From: Charlotte Watkins
Sent: 07 June 2022 12:07
To: Katherine Daniels; Planning
Subject: 22/00967/DISC

22/00967/DISC

Land approx. 1 mile from J East of M40, Part of M40 through Chesterton Parish, Chesterton

Condition 33 and 9

CON 33 Discharge - Proposed Green Roof Build Up

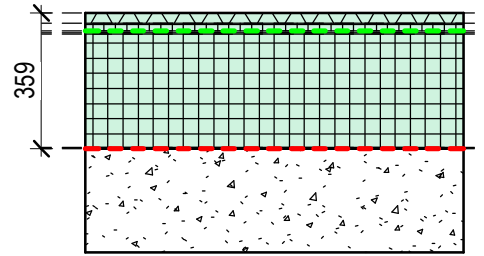
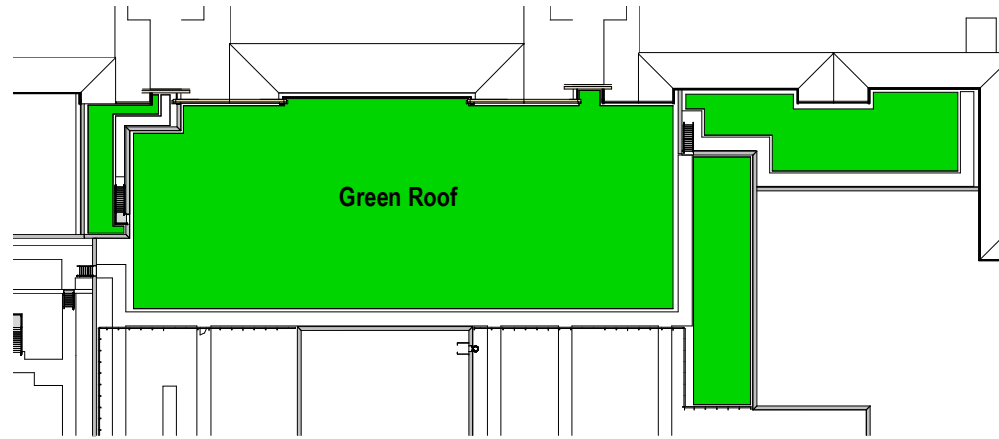
With regard to the above discharge of conditions I am happy for condition 33 to be discharged on the basis of the submitted plans for the green roof by EPR Architects.

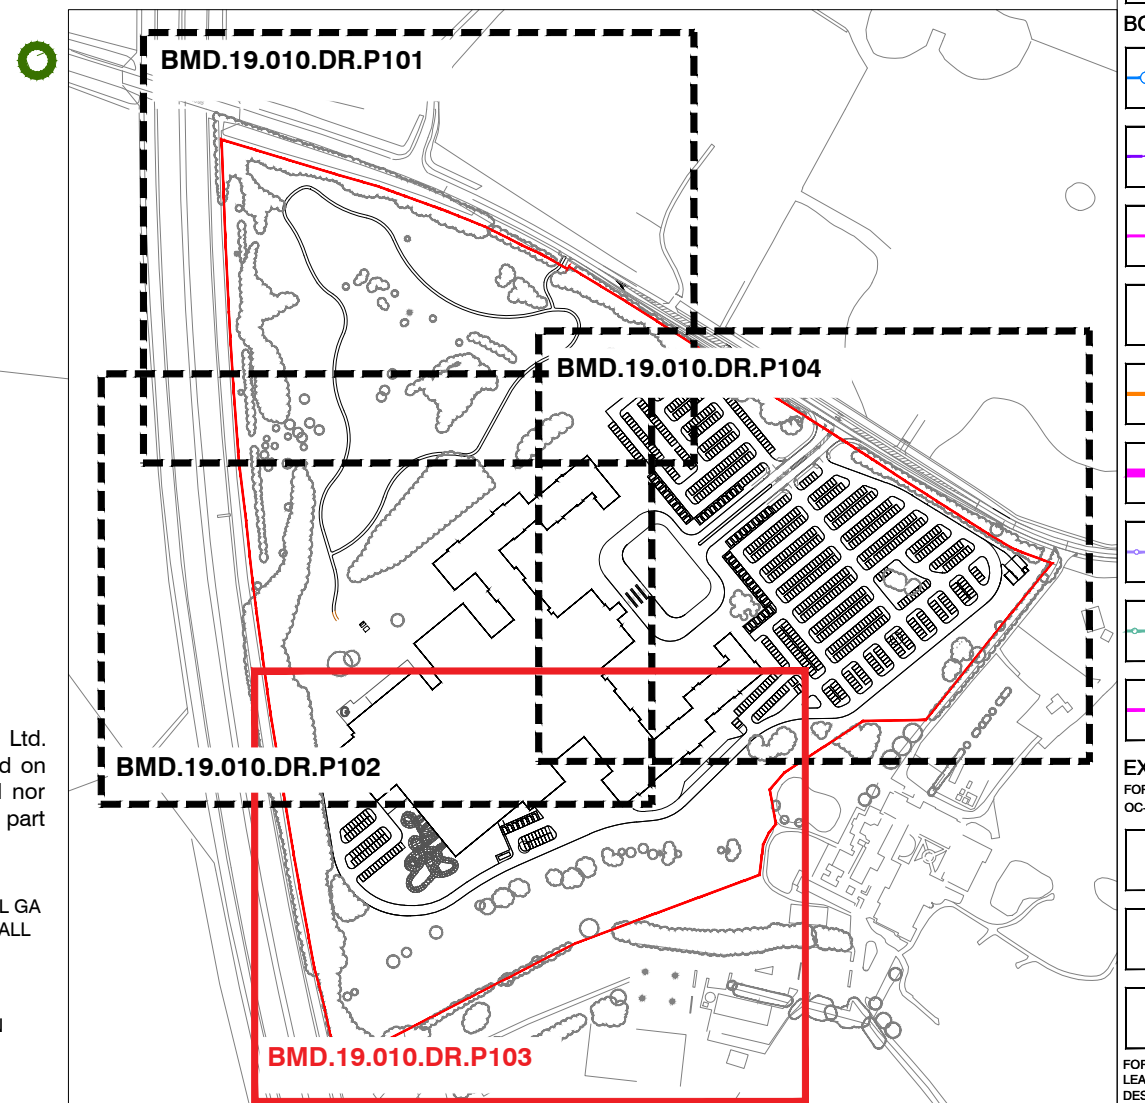
In addition there a large number of wildlife features to be installed across the landscaping – sandy bee banks, bird and bat provisions, hibernacula, log/brush piles, hedgehog and badger fence gaps and I think that some sort of reference to these needs to be included within this management and maintenance schedule even if only as a reference to plans and instructions elsewhere. This would ensure that they are included in the wider landscaping management and not forgotten, blocked up or 'tidied'. If this document is to be used by landscaping contractors it would be easy for these important aspects to be managed incorrectly if they are not mentioned.
